Consultation Response from Emma Mills KC Landscape	
Application No:	2023/90668
Proposed Development:	Erection of B2/B8 Industrial Unit and associated works
Location:	Grange Moor Coachworks, Barnsley Road, Grange Moor, Huddersfield, WF4 4DR
Applicant/Agent:	Acumen Designers & Architects Ltd
Planning Officer	RichardA Gilbert
Date Responded:	17.04.23
Responding Officer:	AR
Responding Ref:	MM22

Landscape Context and Concept, Landscape Design

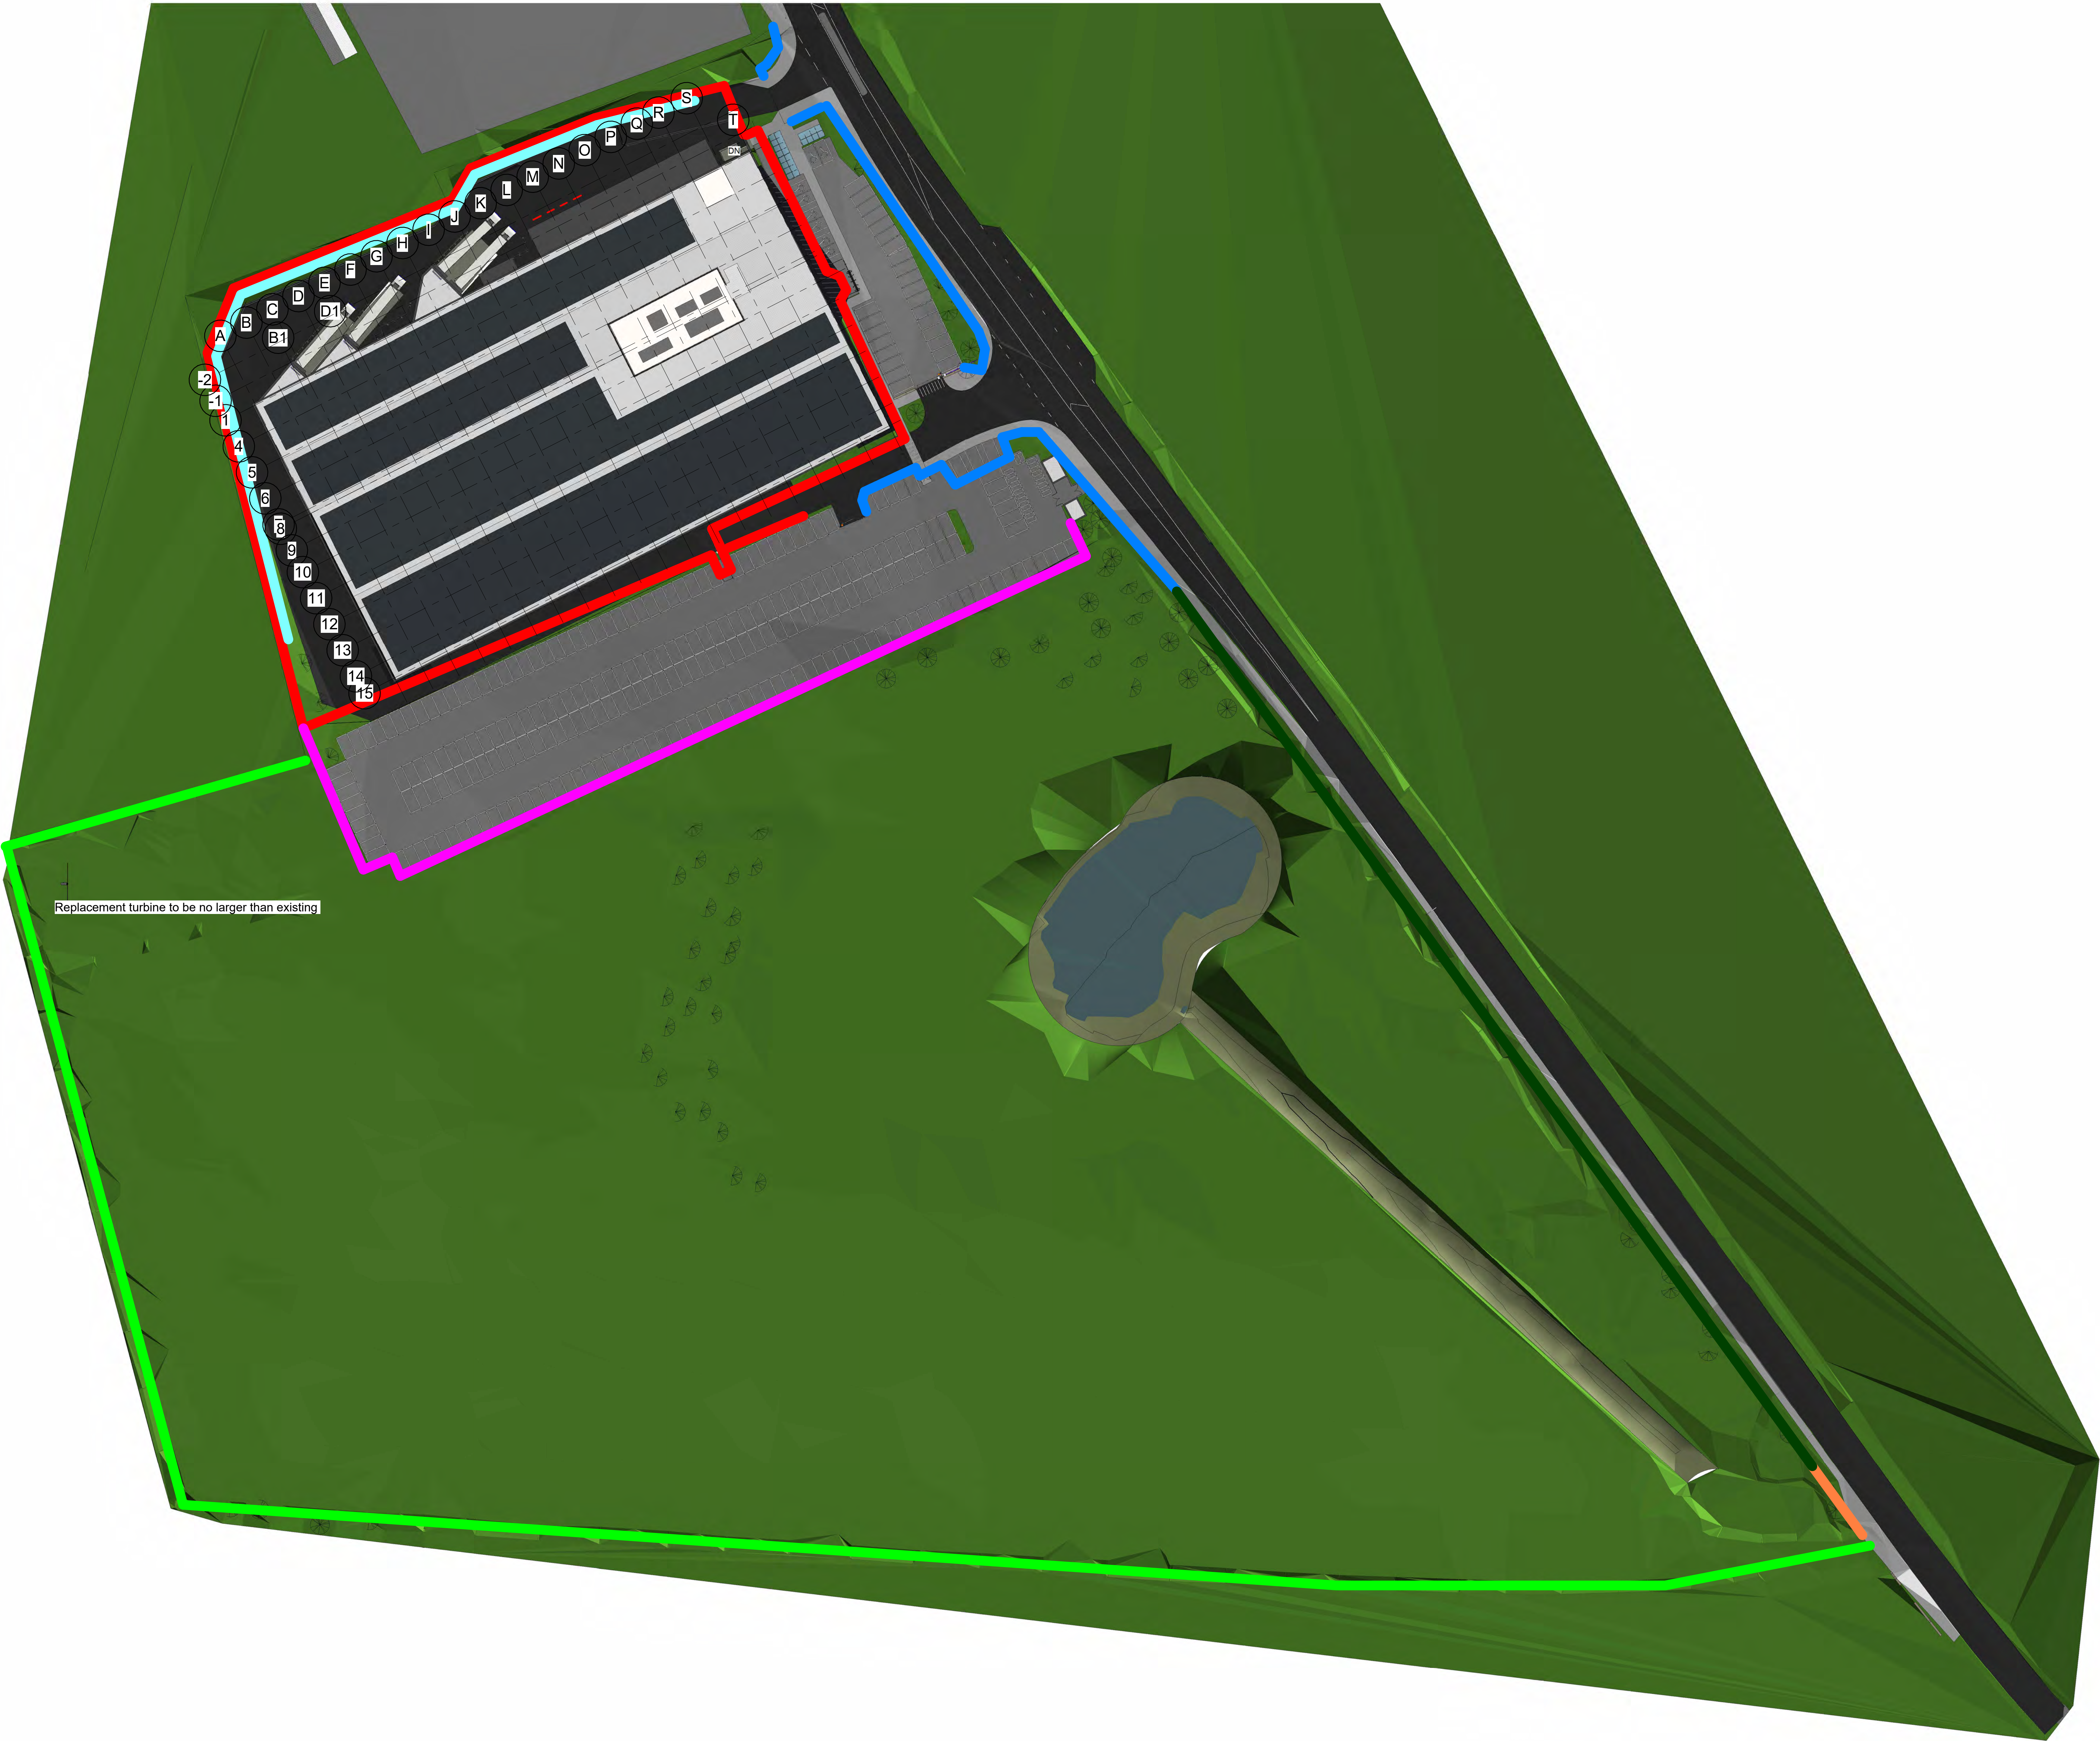
2. We would expect as this proposal is within greenbelt to see a significant level of mitigation planting proposed to visually screen the development. The existing planting proposals are not robust enough, particularly to the southern boundary of the layout. It is clear in viewpoint 10 of the LVA where the existing structure and yard can be clearly seen that a large structure in this location would be visible. We suggest a wide boundary of tree planting (woodland margin) using a native mix of fast-growing species such as Alder, Rowan, Silver Birch and Hazel, would potentially form a good screen within five years.

3. Planting indicated to the front of the development is difficult to assess without further detail. We would also expect this to provide mitigation, it should include large robust varieties of trees and hedgerow. Further supporting detail is needed to be assured it would provide sufficient mitigation. We would also expect to see tree planting **within** the car park areas to avoid dominance of hard surfaces. Planting should be native, habitat forming and cohesive.

6. The proposed 1000mm stone wall to the eastern boundary is in principle acceptable however we would like to see details of the construction and conformation that the stone type and colour is appropriate to the area. The remaining proposed boundary treatments are acceptable.
